Recommendation Report for Planning Permission for Works or Extension to a Dwelling

REF NO: BE/33/19/HH

LOCATION: 17 Frandor Road
Bersted
PO21 5TP

PROPOSAL: Proposed conservatory to the side of the property

*Proposed Conservatory installation, frames white UPVC@
17 Frandor Road, Bognor Regis, PO21 5TP
Proposed Floor plan*

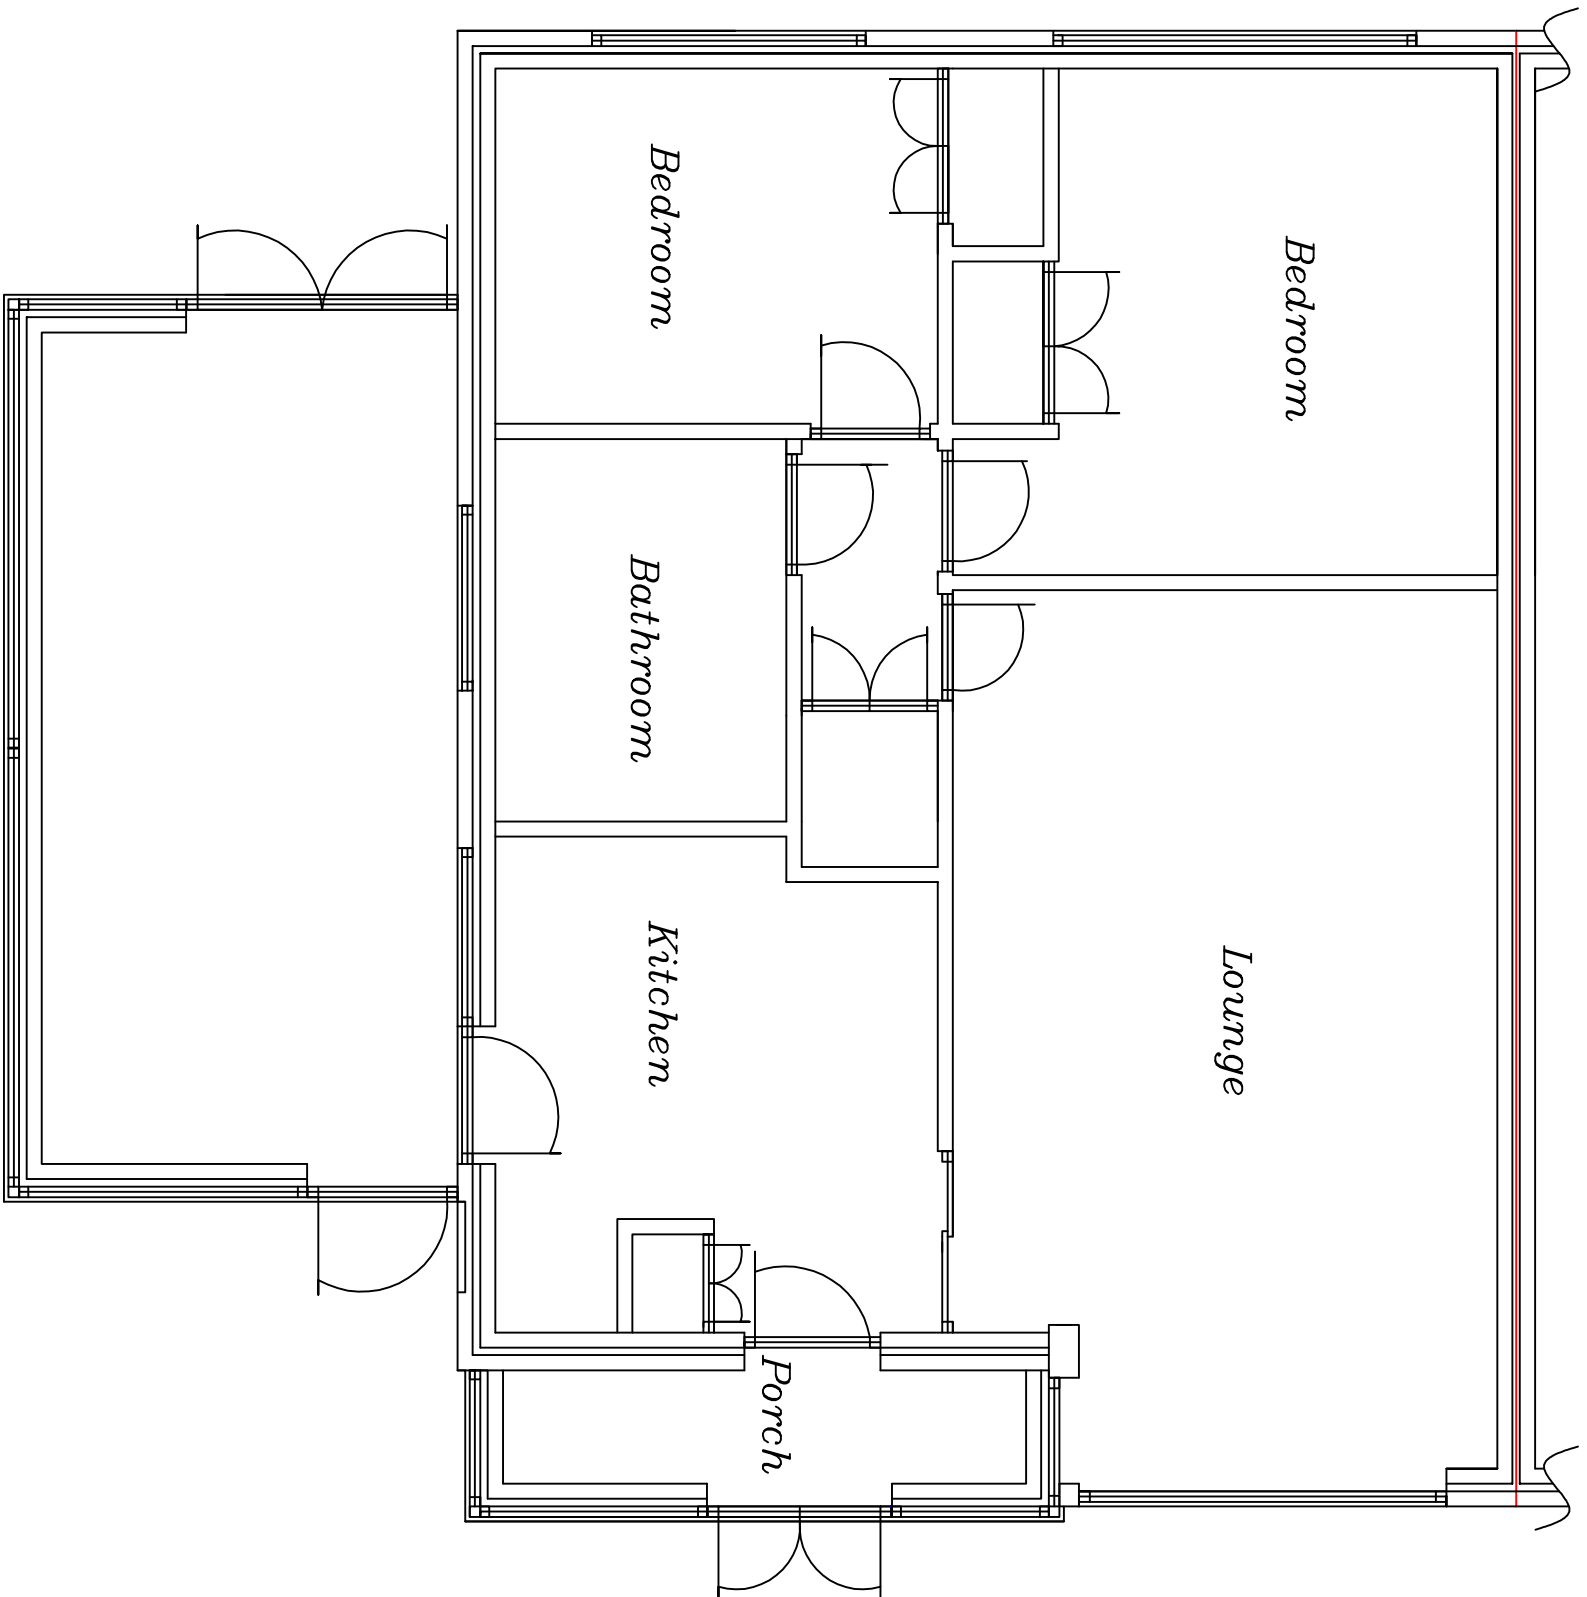
- The plans are incorrect, the land was sold and does not belong to the applicant.
- The plans have no dimensions and could change at a later date.
- Building material should only be stored on the owners land.
- As its on a corner, restricts view onto the road.
- Noise disruption from construction

- The garage and driveway do not form part of the property despite the red boundary line shown on the plan.
- Vehicles that park there will have to be on the road and there is insufficient parking.
- Foul manhole will be contained within the development and permission should be sought from Southern Water for works which will affect this.

- Land ownership is a private legal matter. The applicants have submitted a certificate to say they own the land.
- The plans are scaled which show the proposed dimensions.
- Due to the siting of the development which is more than 6m from the road it is not considered to adversely impact upon visibility at the junction.

The conservatory is modest in size and is not considered to appear unduly dominant upon the street scene with 8m retained to the front and 6m to the side boundary.

There is currently a fence that runs around the rear and side of the property retaining 6m to the boundary with vehicle parking beyond this. Part of the fence will be removed to make room for the conservatory however there will still be room for around 3 cars which is considered sufficient for the size of the dwelling.

*Proposed Conservatory installation, frames white UPVC@
17 Frandor Road, Bognor Regis, PO21 5TP
Proposed North elevation*

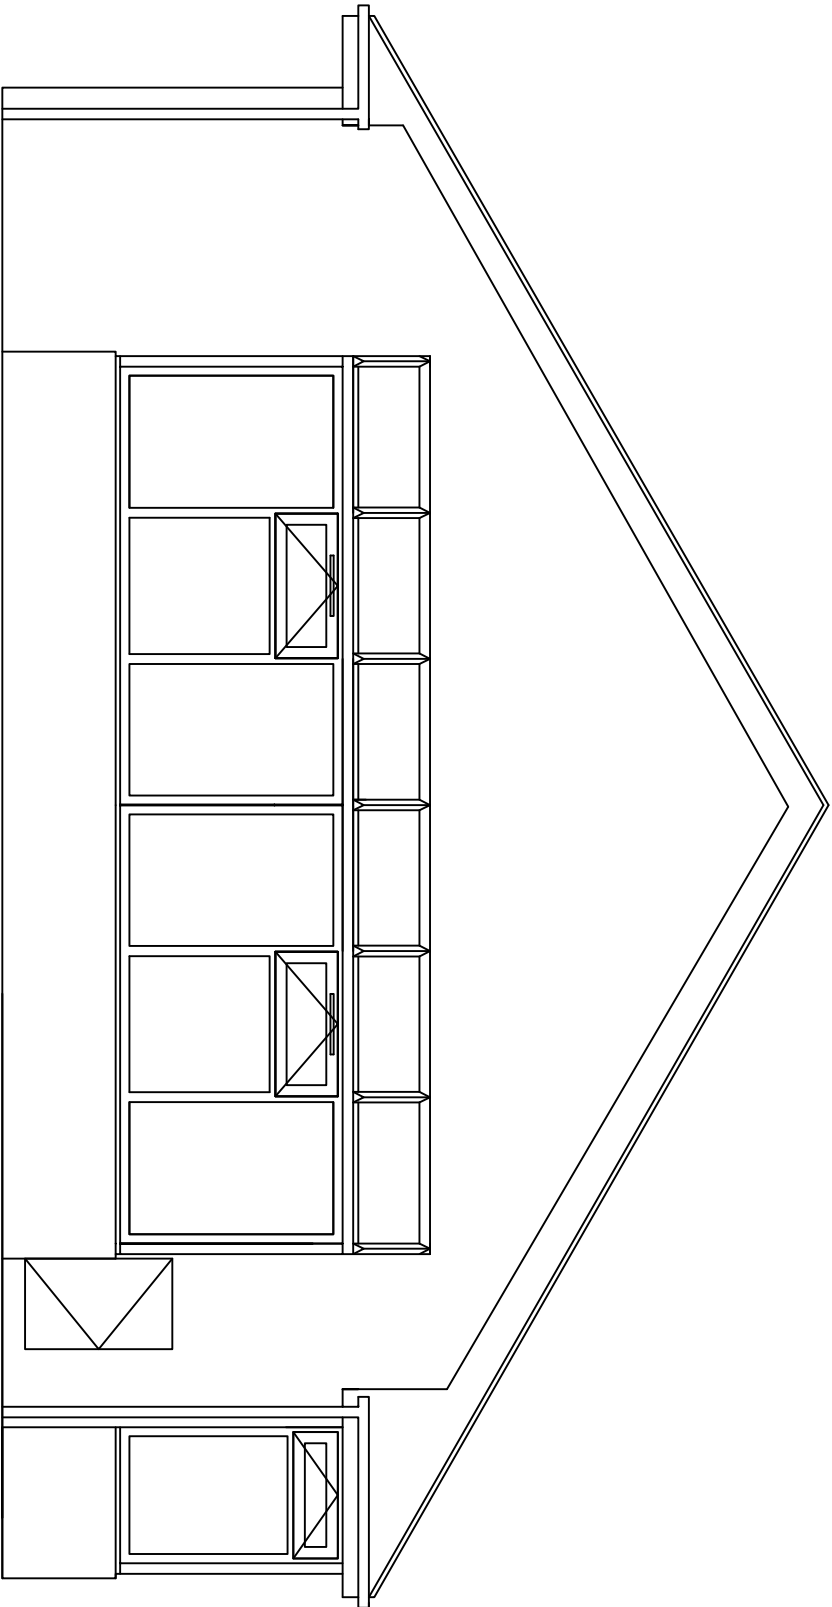
The conservatory will be constructed to a maximum height of 2.75m with a slight lean to roof. It will have a width of 2.7m and extend around 6m along the side elevation of the dwelling.
